LSC TRANSPORTATION CONSULTANTS, INC.
2504 East Pikes Peak Avenue, Suite 304
Colorado Springs, CO 80909
(719) 633-2868
FAX (719) 633-5430
E-mail: lsc@lsctrans.com
Website: <http://www.lsctrans.com>

Esteban Rodriguez Subdivision Sketch Plan
Master Traffic Impact Study
(LSC #S224630)
August 15, 2023

LSC Responses to EPC TIS Redline Comments

Figure 3
 Existing Traffic, Lane
 Geometry, Traffic
 Control, and LOS

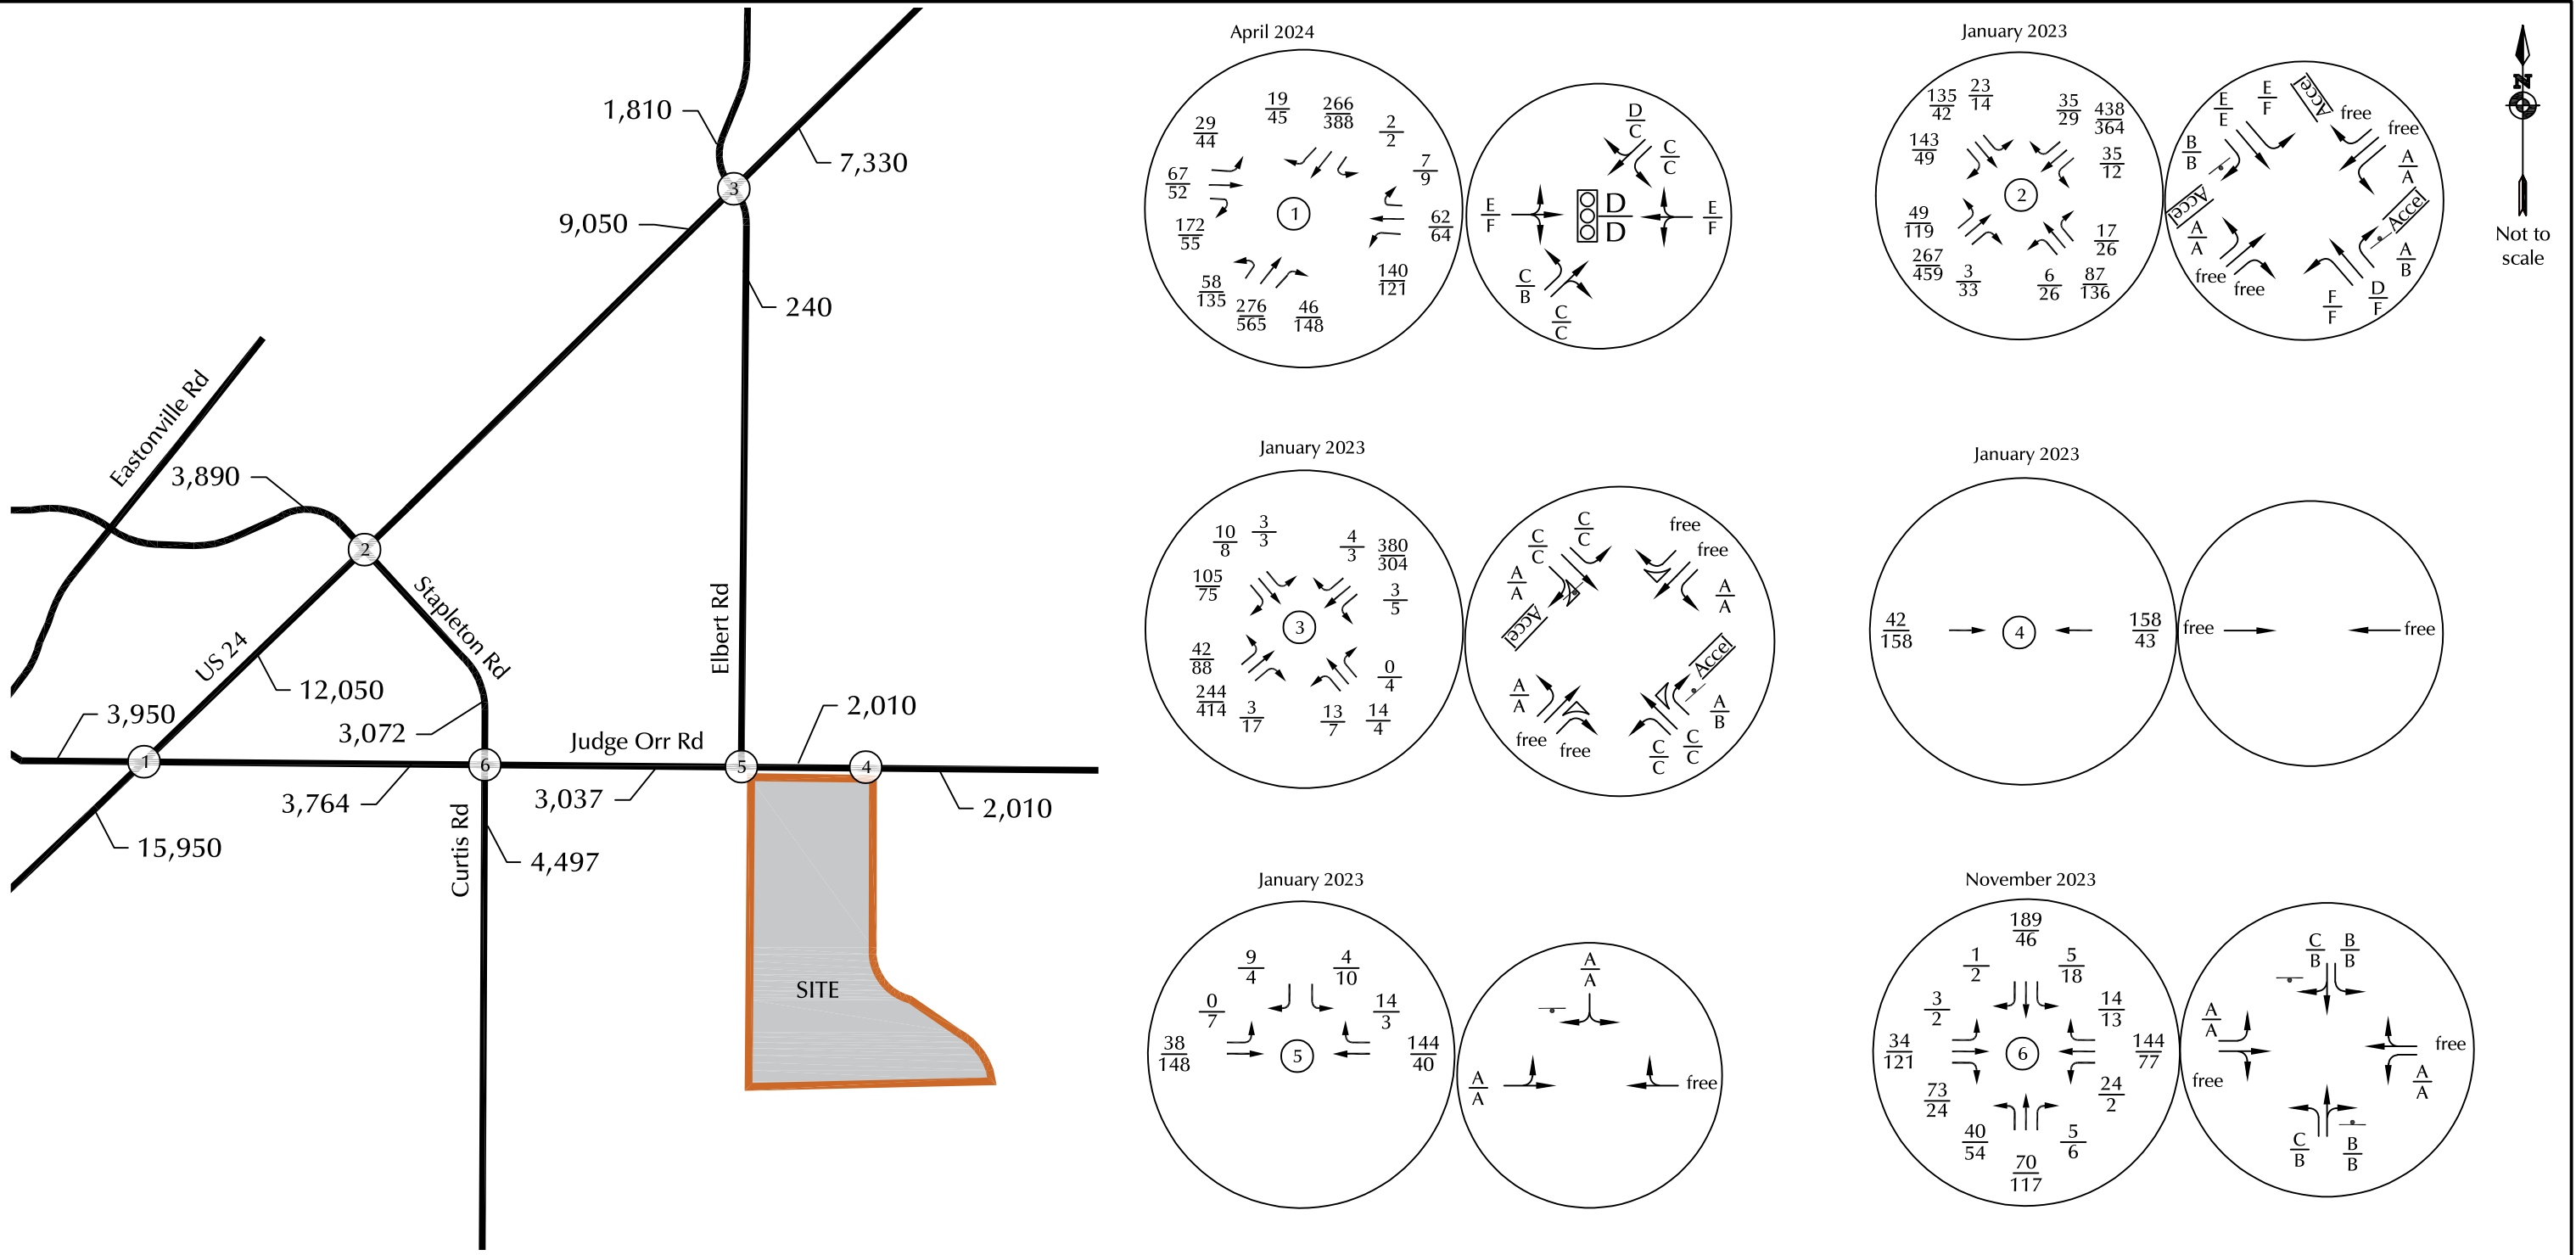
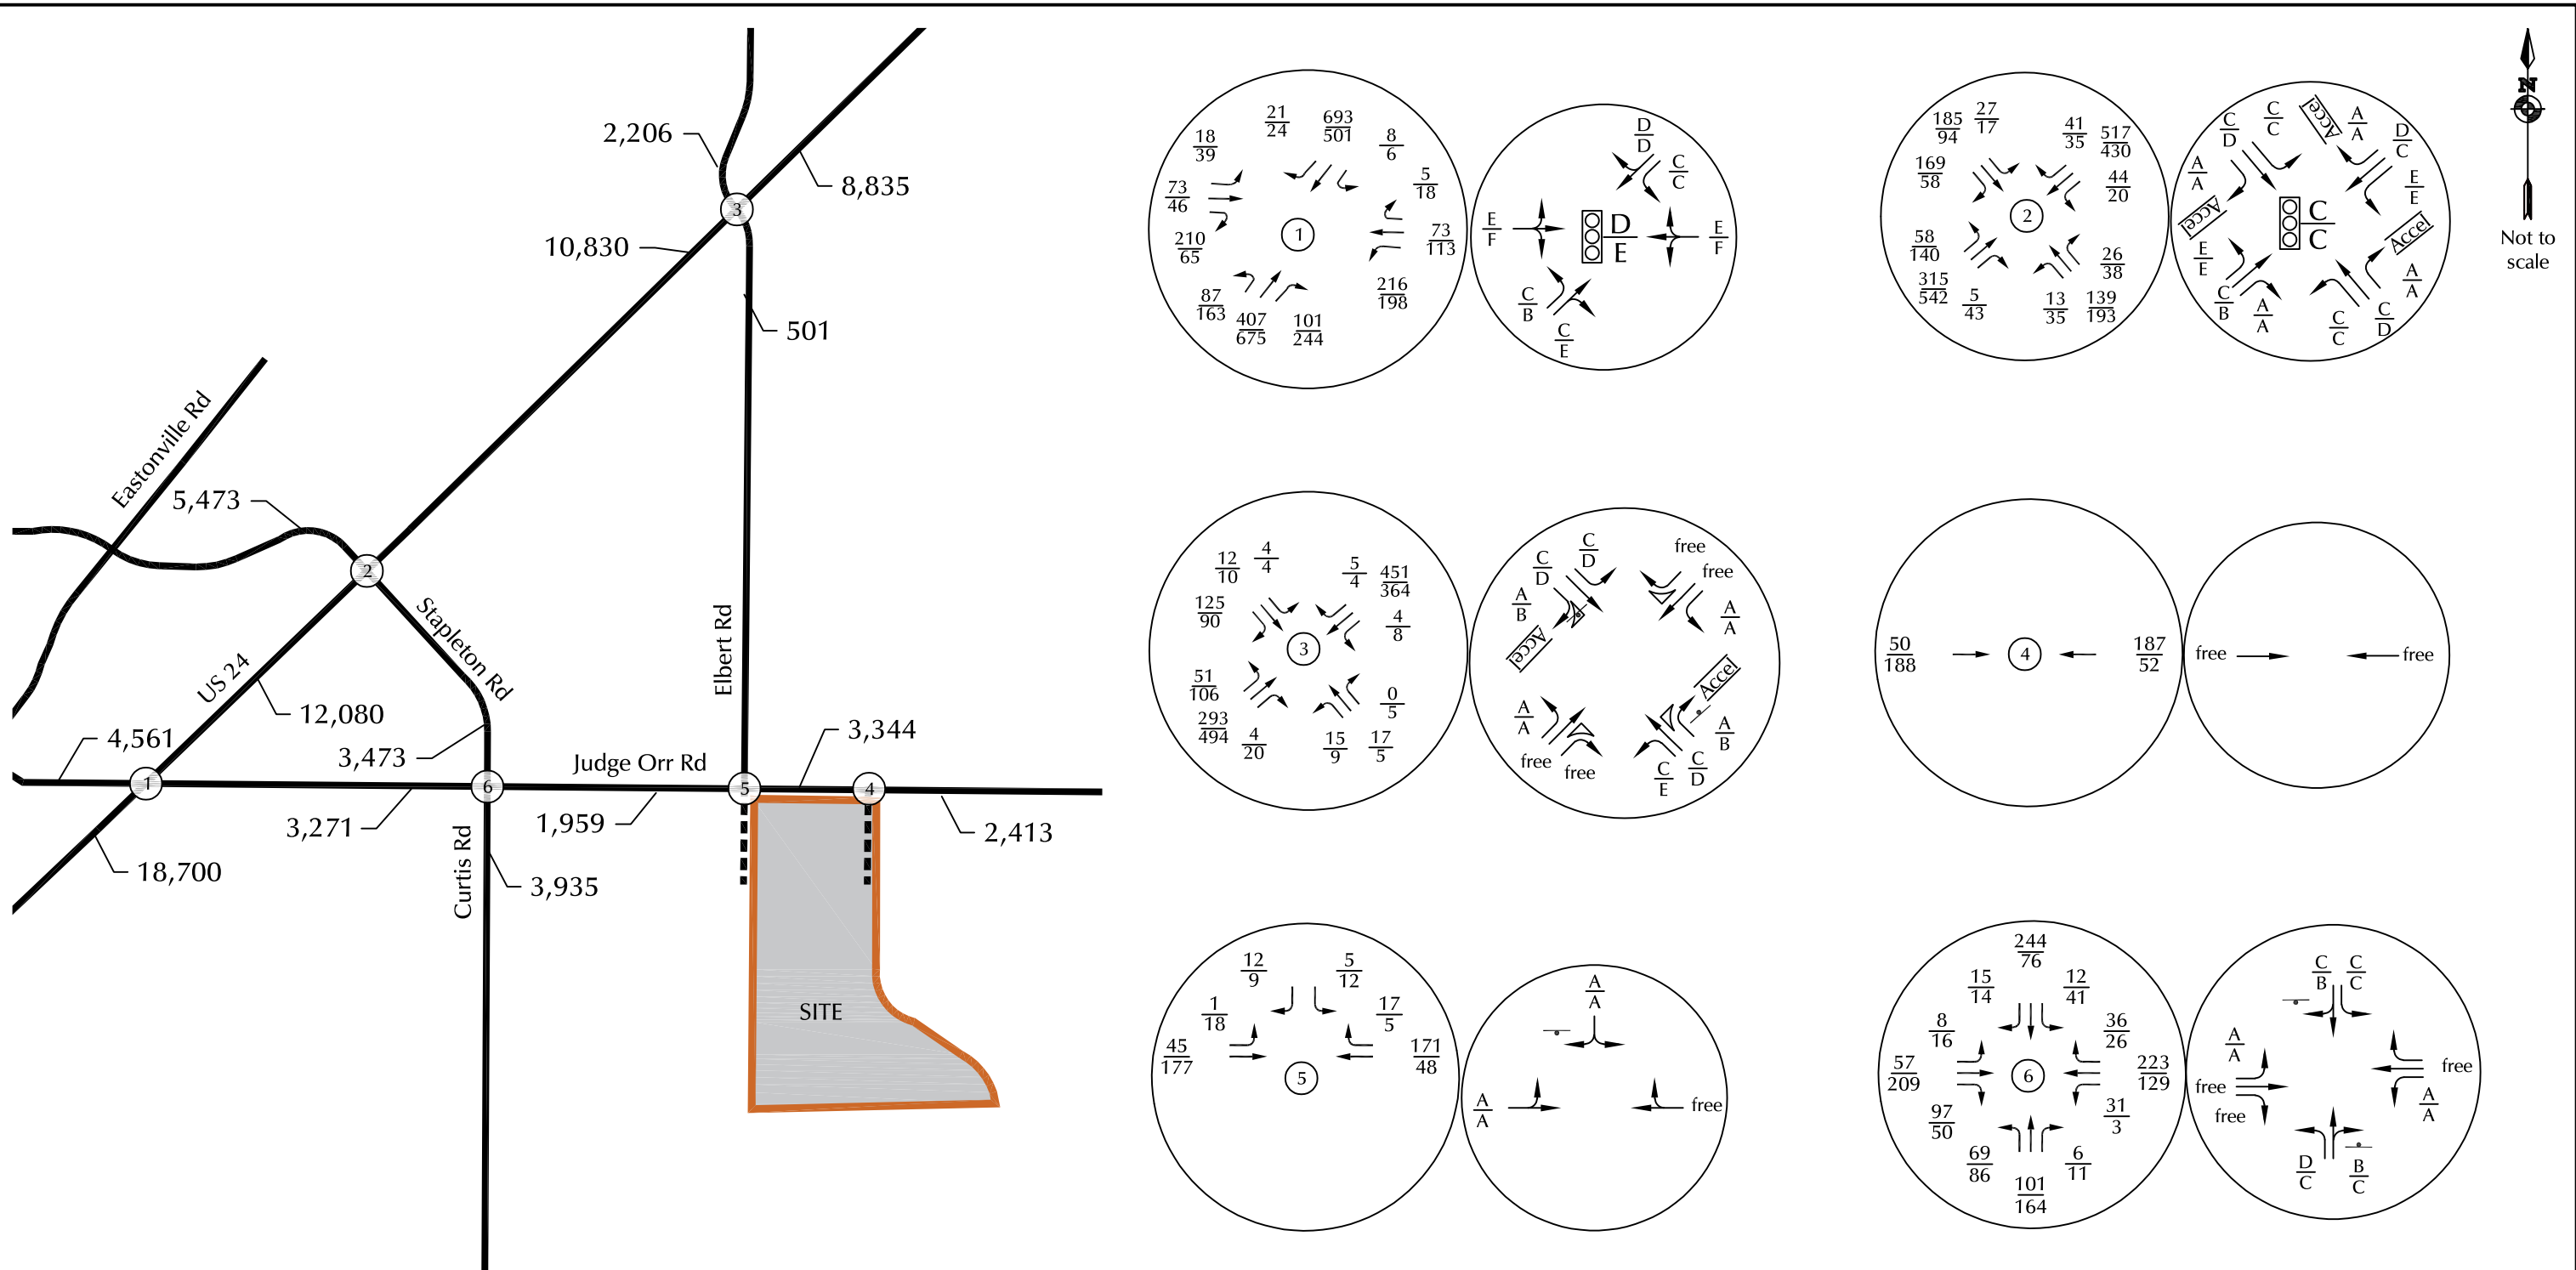
There are some discrepancies between Synchro models, figures, and descriptions about whether Judge Orr Road is a two-lane or four-lane highway at the location of the E Access. Please make this consistent throughout the study.

LSC Response: Figures and LOS analysis results have been updated along with the Synchro models, the figures, and the report narrative.
